Your Ref: OWPC6067
Our Ref: M/56/15/HH 15-05-2015
Please ask for:
Ross Leal

Front/side & rear extensions & outbuilding to front elevation.

31 Sea Way Middleton-on-Sea

Thank you for your internet representation made on 18th June 2015 which has been recorded as '**an objection**' with the comments as follows:

Proposed Elevations  
Sections B-B  
C-C  
D-D

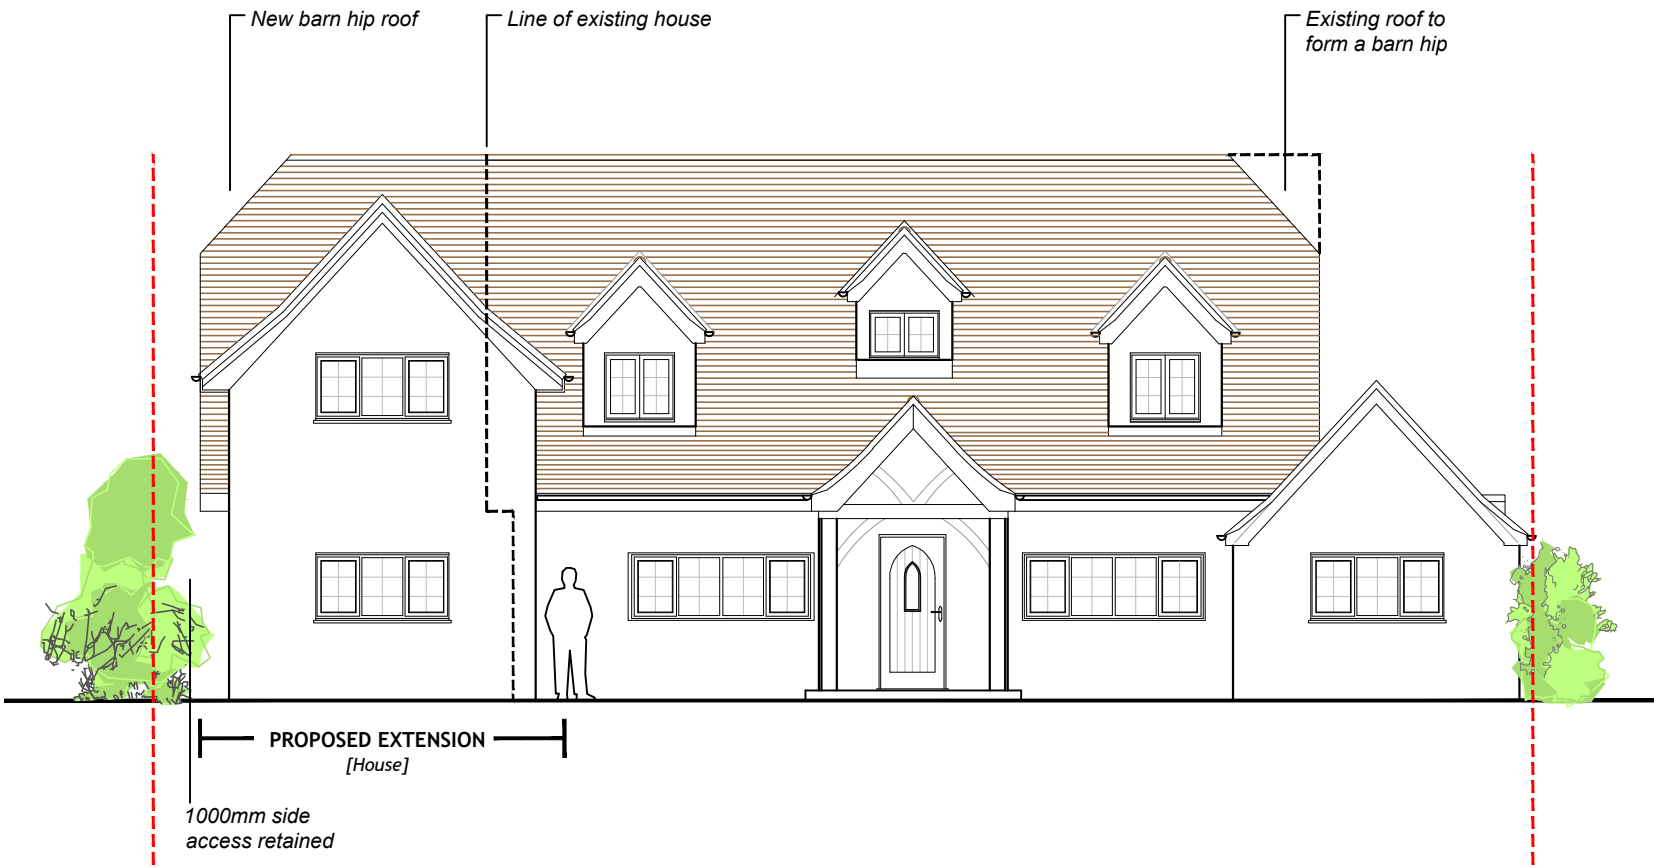
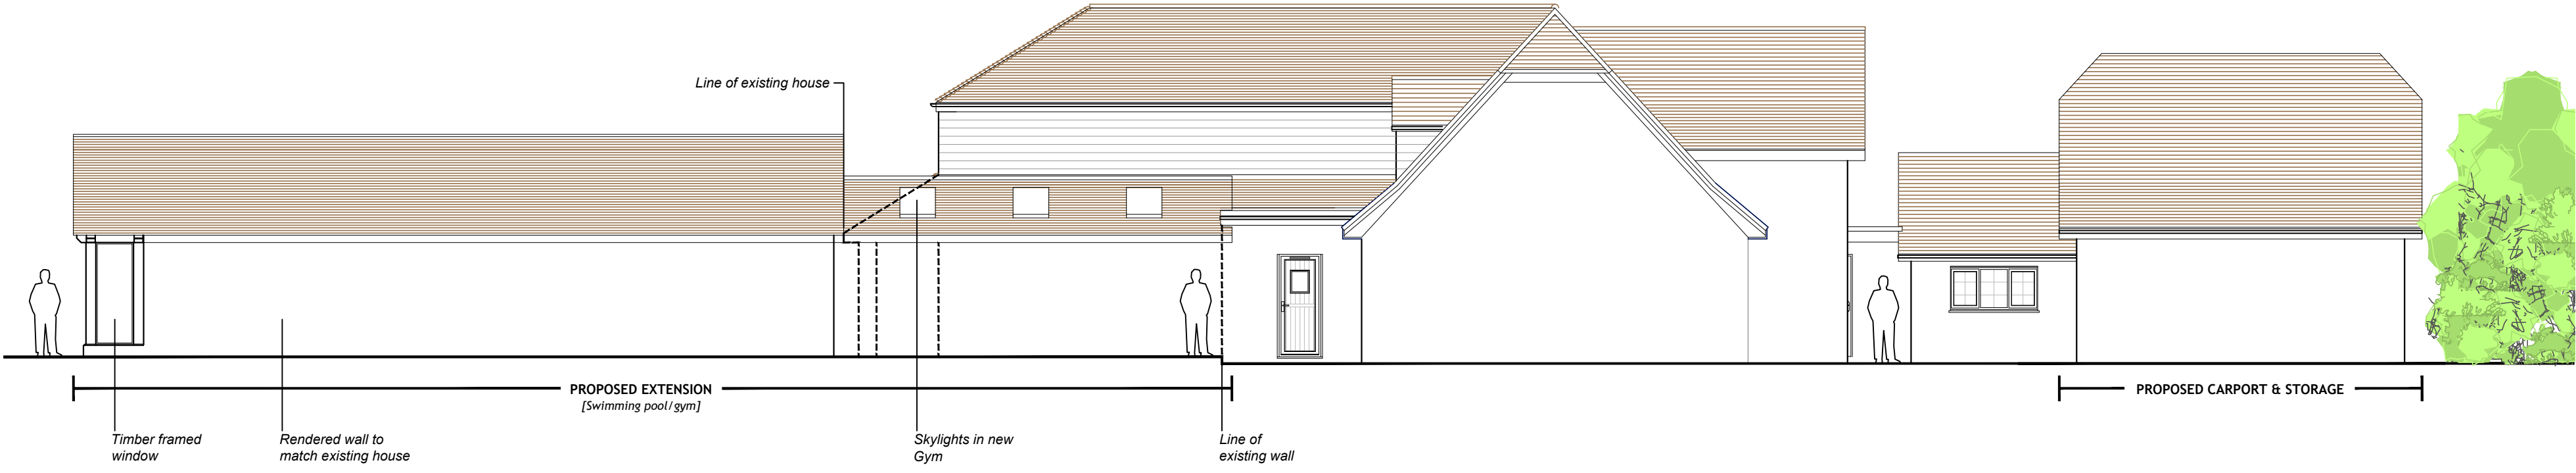
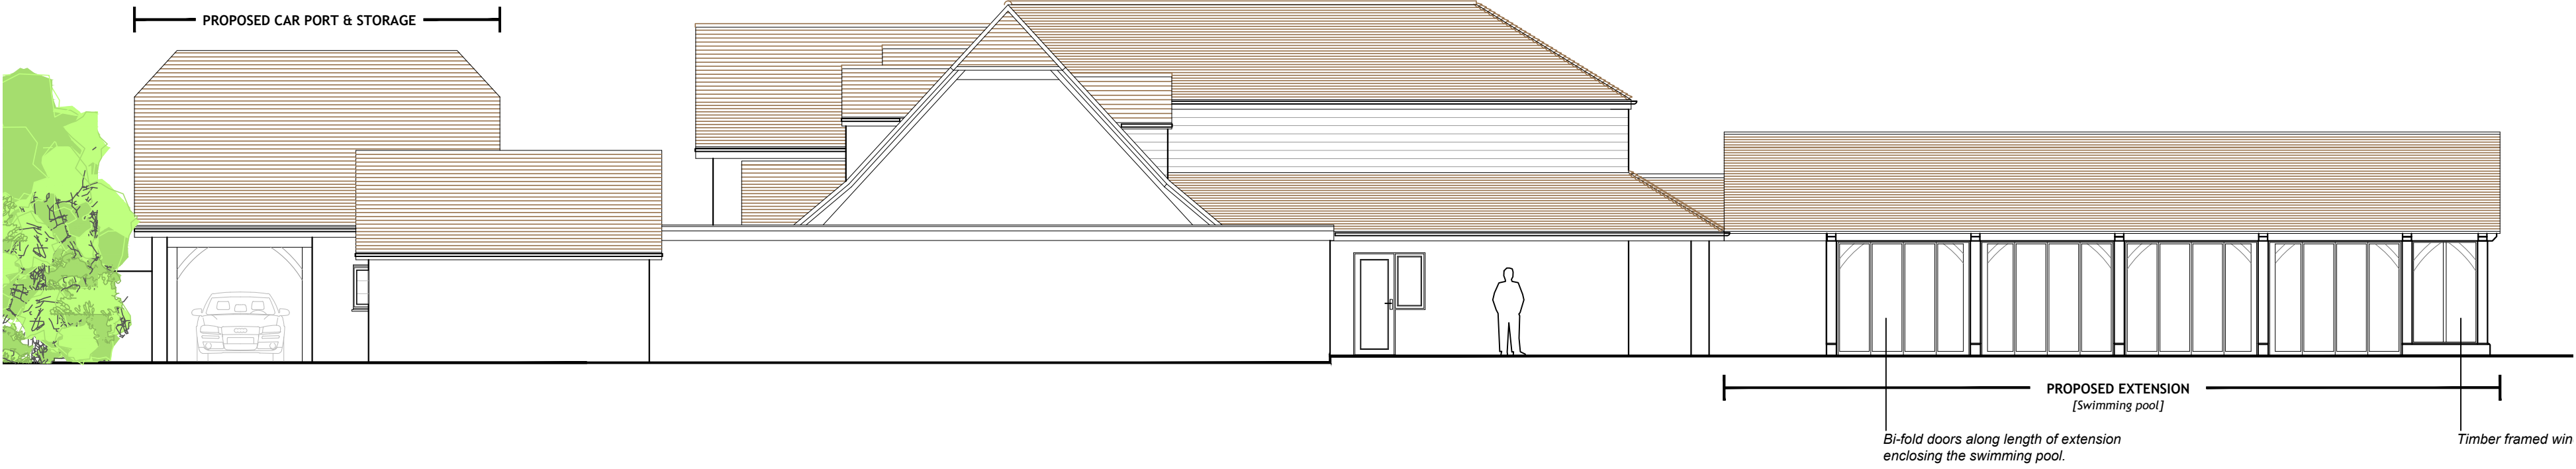
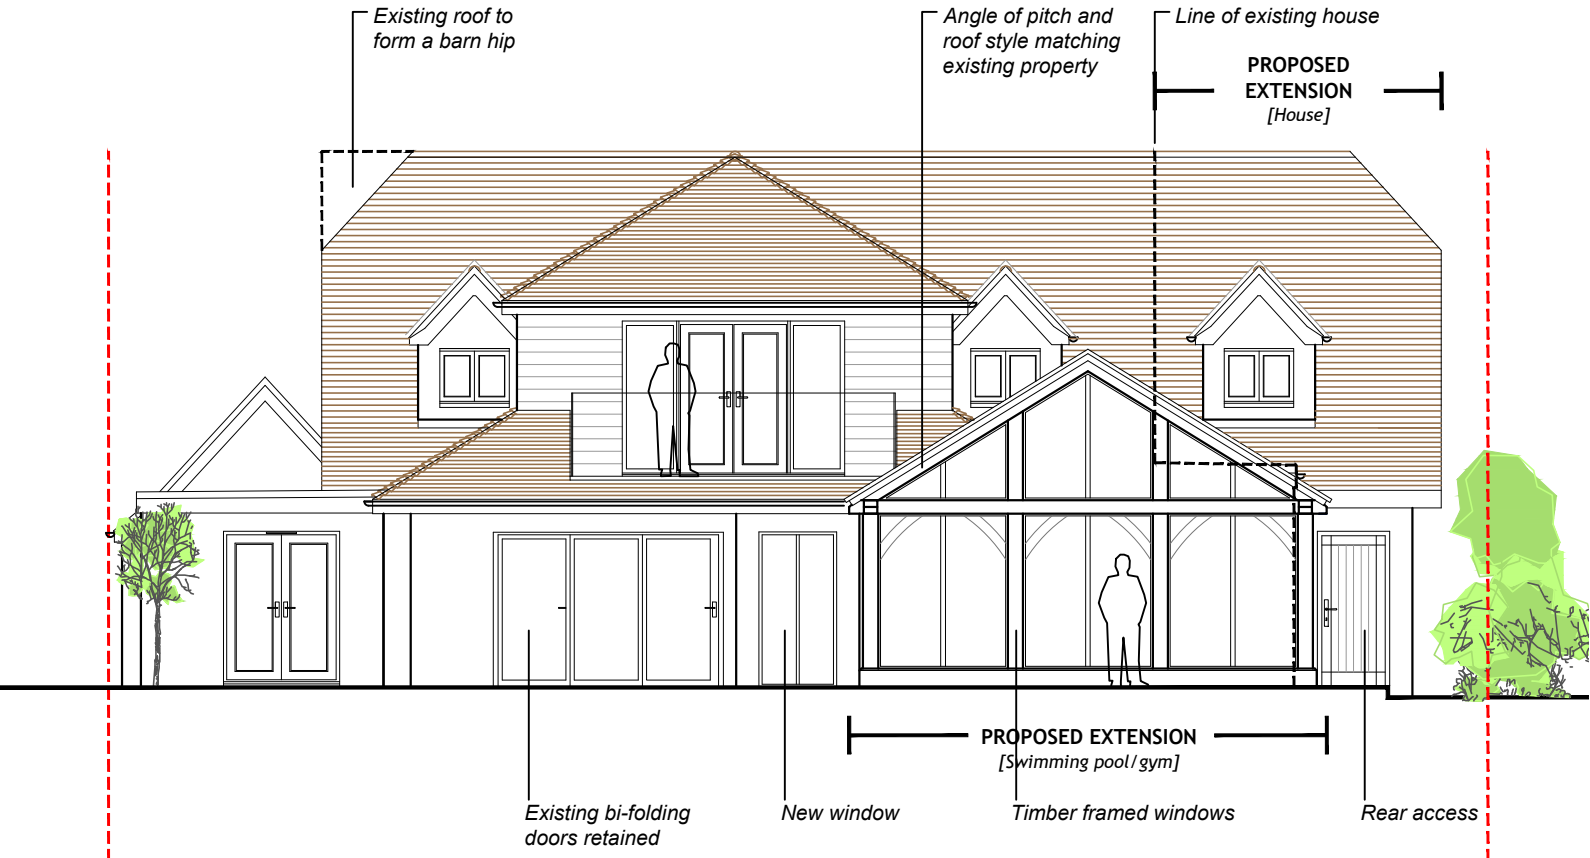
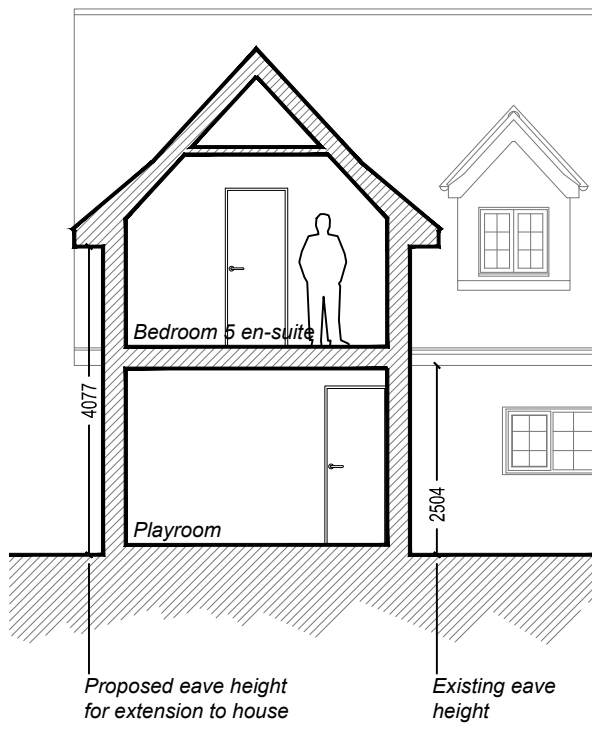
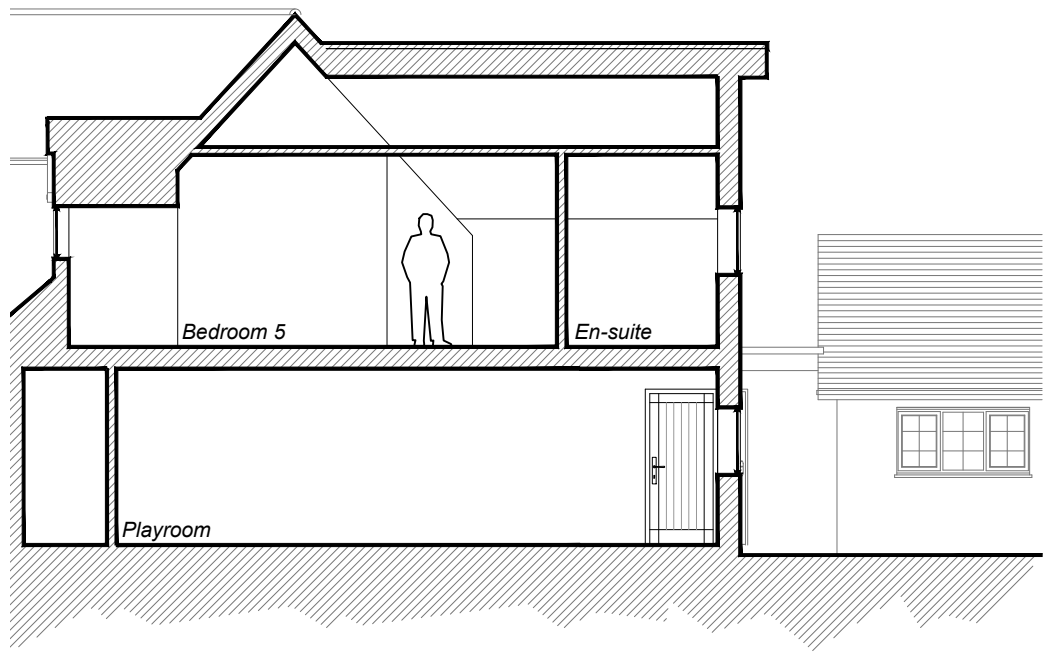
The proposal to build a new two storey garage in the front garden is out of keeping with the house and the area. It is described as a carport but is in fact a two storey garage without a garage door, although the design allows a garage door to be fitted at a later date. The new garage which include the car port, two store rooms and a room over, is very large and built a long way in front of the existing building. The building has a steeply pitched roof exceeding 6m in height. It will be clearly visible from the road and the neighbouring properties. The garage building is inappropriately sized and located. It should also be noted that the proposed first floor plan is incorrect as it does not show the first floor of the garage, it merely shows the roof. The first floor room in the garage can be seen on the section.

The proposed roof over the swimming pool is very large (approximately 15m x 7 m) and will be visible from the neighbouring gardens and from the greensward. It has a pitched roof which will be more than 4m high. This is a significant structure completely out of keeping with the size of plot and the house and will be very unsightly given its disproportionate size.
